City of Albuquerque

December 20, 1999

RE: Grading and Drainage Plan for Dickey's Barbecue (F16/D19) Submitted for Grading Permit and Building Permit Approval, Engineer's Stamp Dated 11/19/99.

RE: Grading and Drainage Plan for Dickey's Barbecue (F16/D19) Submitted for Grading Permit and Building Permit Approval, Engineer's Stamp Dated 5/17/99, Supplemental Information Dated 6/10/99.

Job title
DICKEY'S BARBECUE
PAN AMERICAN FRWY NE
ALBUQUERQUE, NM
PROJECT MANAGER
NICK PIRKL
sheet title
GRADING & DRAINAGE PLAN

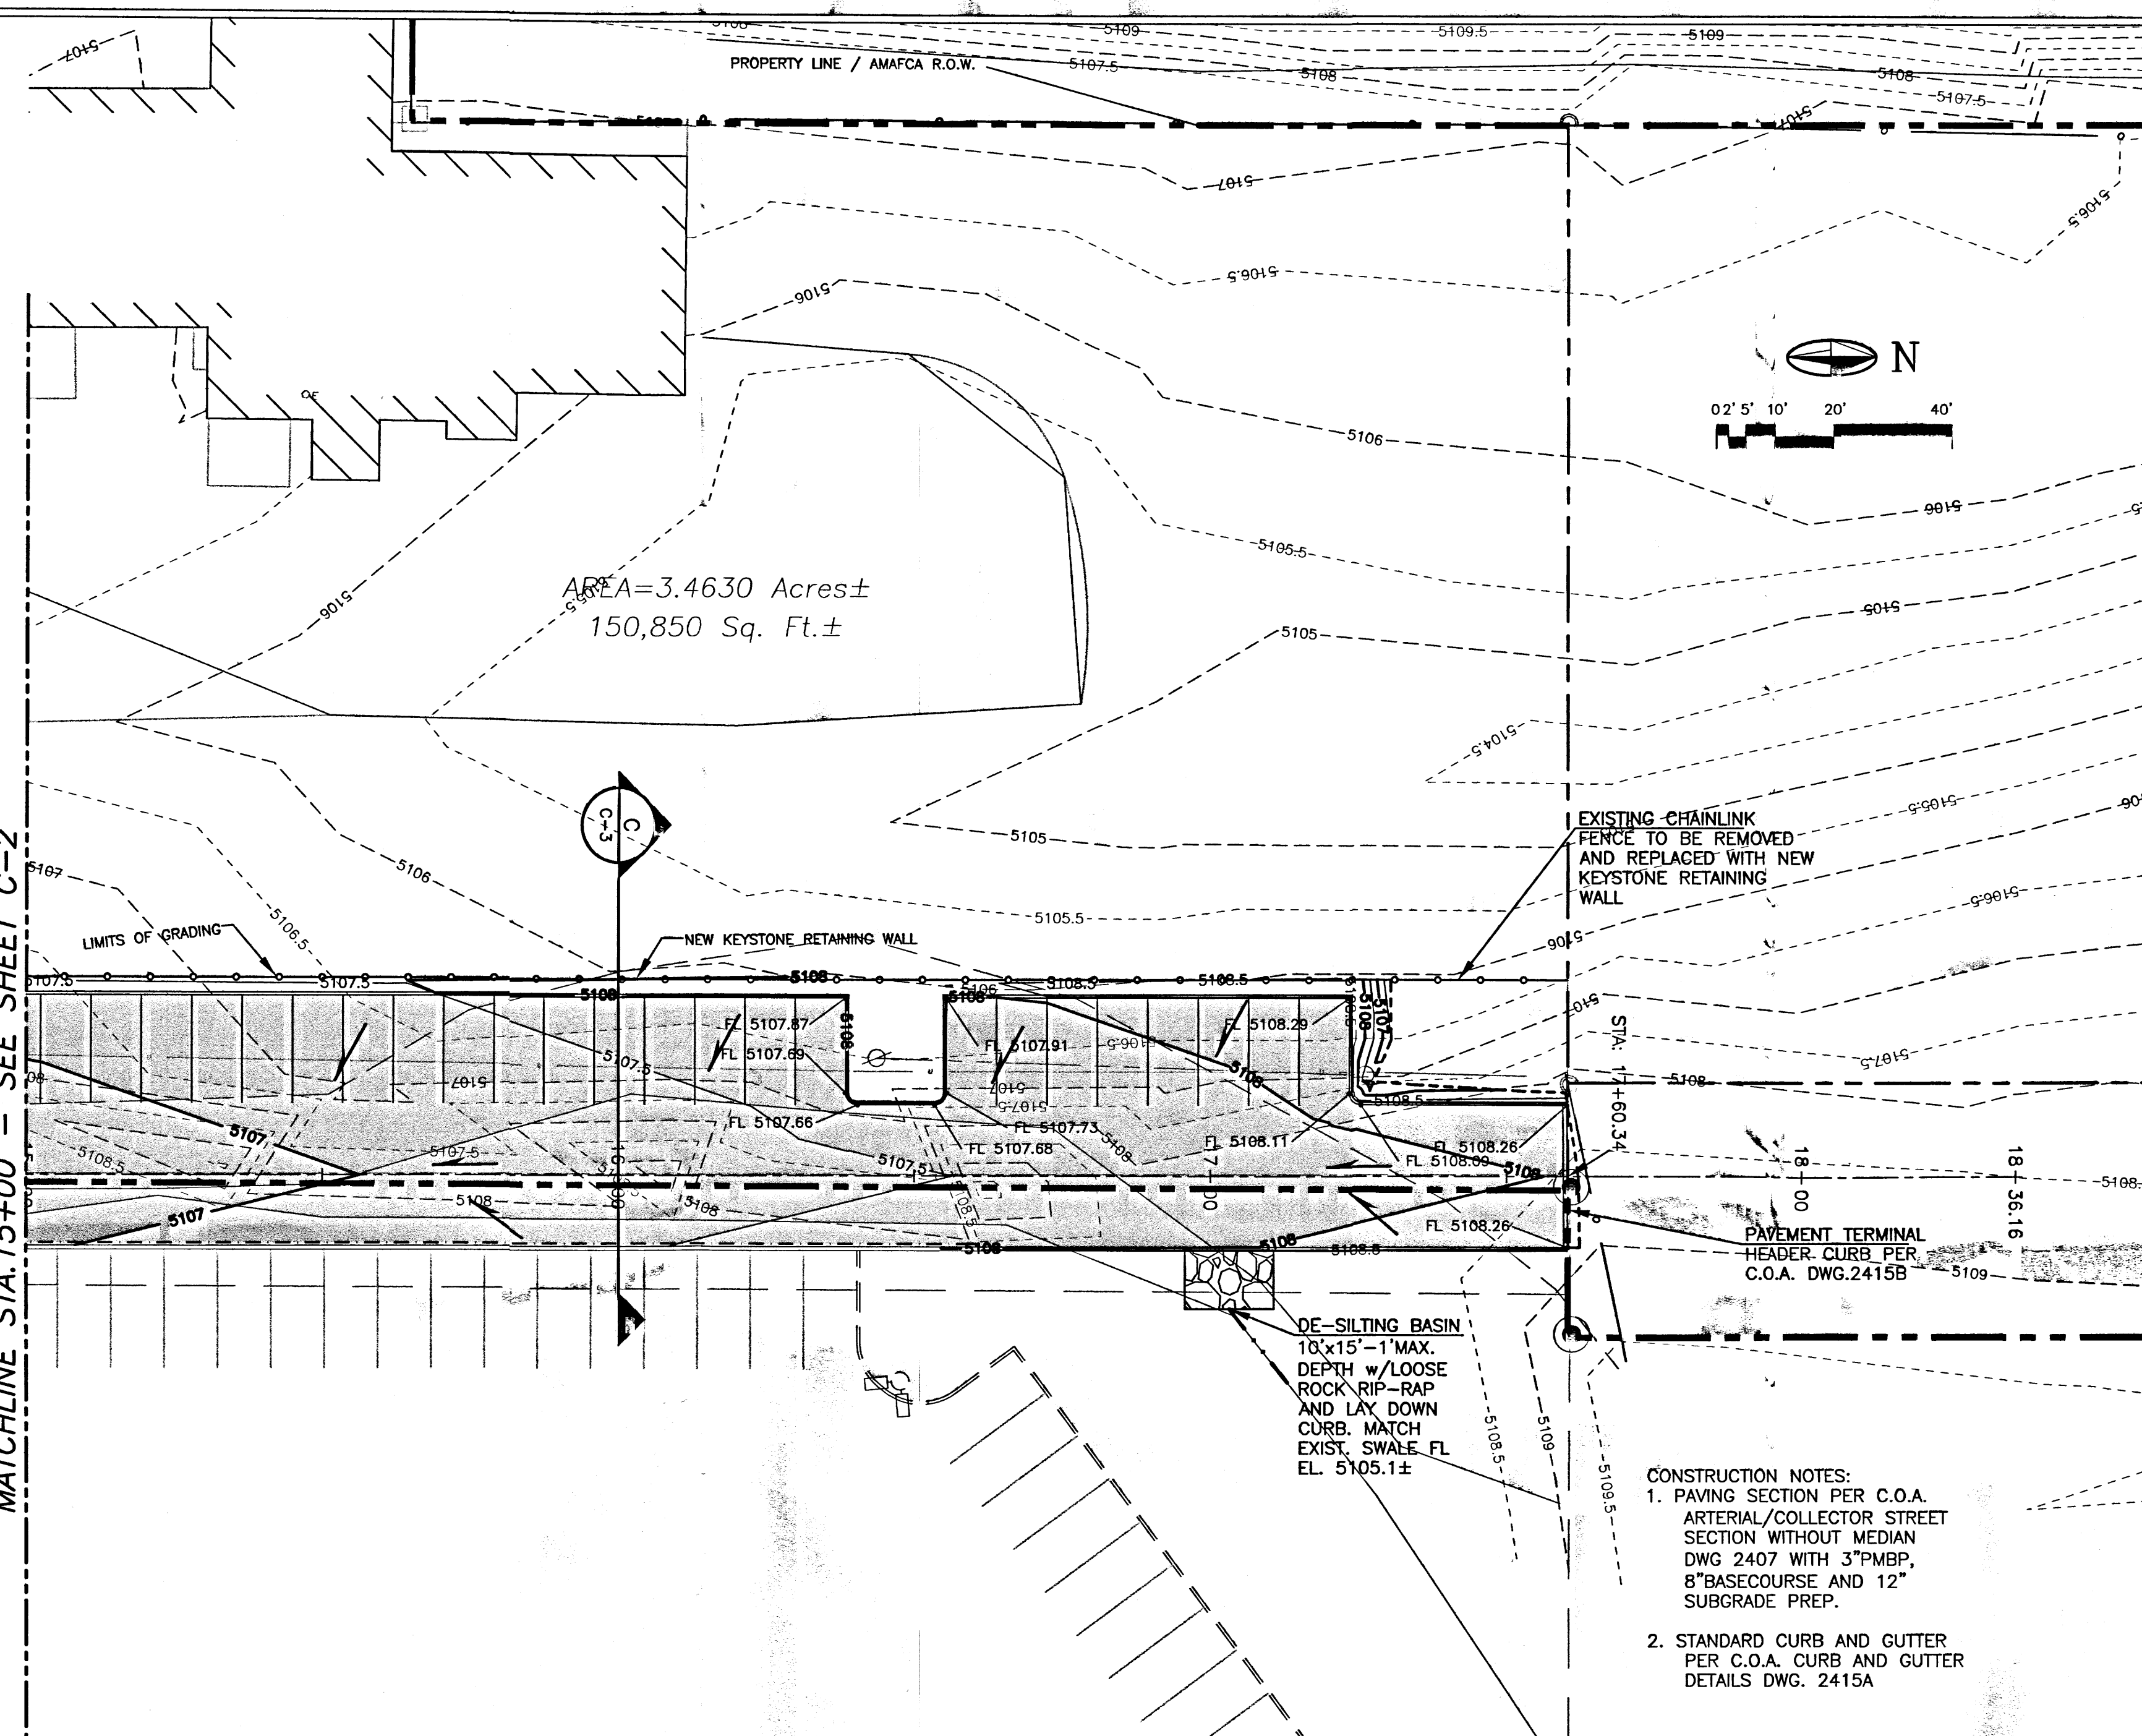
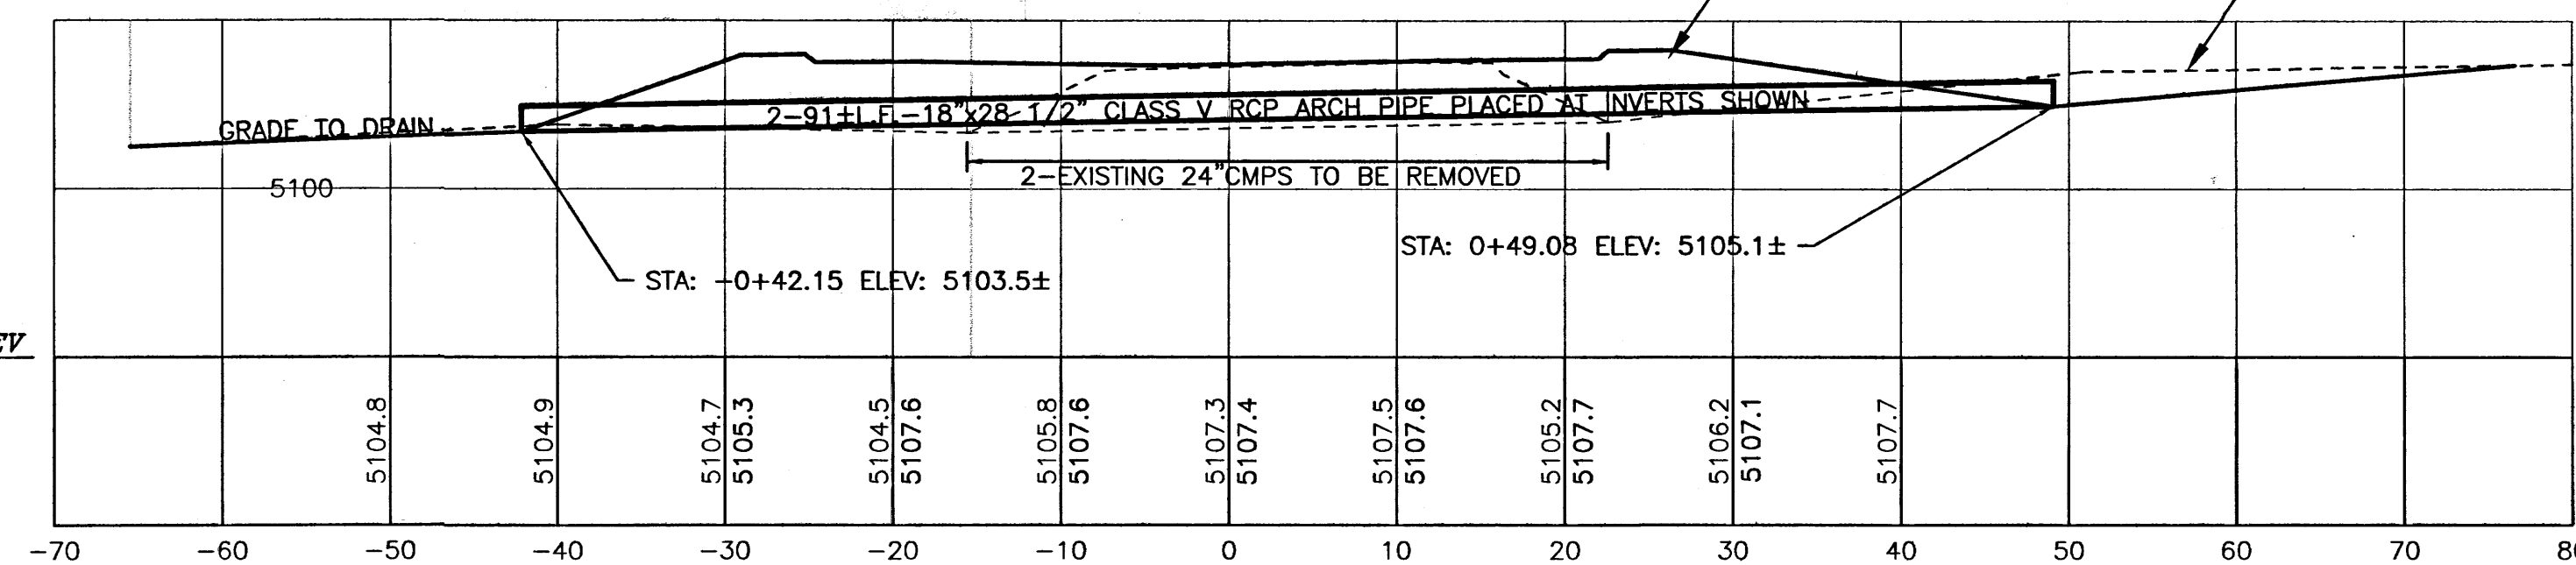
Although the drainage concepts may not change, the Grading and Drainage Plan must be updated to match the revised site plan per the TCL comments. Please resubmit the TCL with the drainage resubmittal. On the updated plan, please revise the Proposed Conditions section per my previous comments.

- 1. It is unclear from the calculations whether the off-site drainage basins were considered fully developed. The design must account for the fully developed runoff.

- 2. The off-site basins maps were unclear. On the 1" = 500' map, where is the Dickey's site and what is the total area that drains to the existing bar ditch? Please include flow arrows to indicate which way the other sites drain. (Do only the pink and blue areas drain to the ditch?) On the 1" = 200' map, where is the Fuddruckers site? (It is hard to tell how these maps go together)

- 3. Provide a cross-section for the existing bar ditch and provide capacity calculations for the ditch. Is this ditch within the highway department right-of-way? During the 100-year event, does the runoff overtop the entrance driveway and trench drain?

- 4. Show the existing drainage basin boundary between the north and south basins for the site.
- The traffic circulation layout (TCL) must be approved concurrently with the drainage plan. Please resubmit the TCL with the drainage resubmittal.

1. The analysis which was previously submitted accounts for the fully developed runoff conditions. The offsite basins which presently contribute to the bar ditch along the I-25 Frontage Road (refer to Exhibit B; 1":500' scale) were calculated for the developed conditions and were approved in the Fuddrucker's Drainage Report (F17/71).

The offsite basin which will contribute to the bar ditch in the interim condition, since its' flows cross the Dickey's site, was only considered in the undeveloped condition (see Exhibit A; 1"-200' scale). These flows will not cross our site in the developed condition because this basin is a portion of a site which has frontage along the AMAFCA North Diversion Channel. This site will be re-graded in the developed condition to have its flows directly enter the Diversion Channel.

2. The offsite basin maps have been revised. The 1":200' map has been labeled Exhibit A and the 1":500' map, Exhibit B. Exhibit B (1":500' map) is a copy of the offsite drainage basin map as approved in the Fuddrucker's Drainage Report (D17/71). The pink and blue shaded areas are the basins which contributed to the I-25 Frontage Road bar ditch at the time of Fuddrucker's approval. The flow arrows as included on this map have been traced over to make them more visible. Exhibit A (1":200' map) was included to show

An additional exhibit, C, has been added as an overall map of the contributing basins to the bar ditch upon development of our site. This map shows the previously accounted for flows (report D17/71) in pink and the proposed flows in yellow.

3. A cross-section and capacity calculations for the bar ditch are attached for your review. It does fall within the highway department right-of-way.

The runoff from the 100-year flows will overflow the trench drain, but will be contained within a dip section located at the entrance of Dickey's Barbecue. This solution is necessary because the placement of a culvert under the entrance would require the grades to be raised up to an elevation which makes the site impossible to drain. A calculation showing the dip section capacity has also been attached for your review.

- 4. The existing basin boundary between the north and south basins has been added to Exhibit A.
- 5. The site and landscape plan have been attached for TCL review.
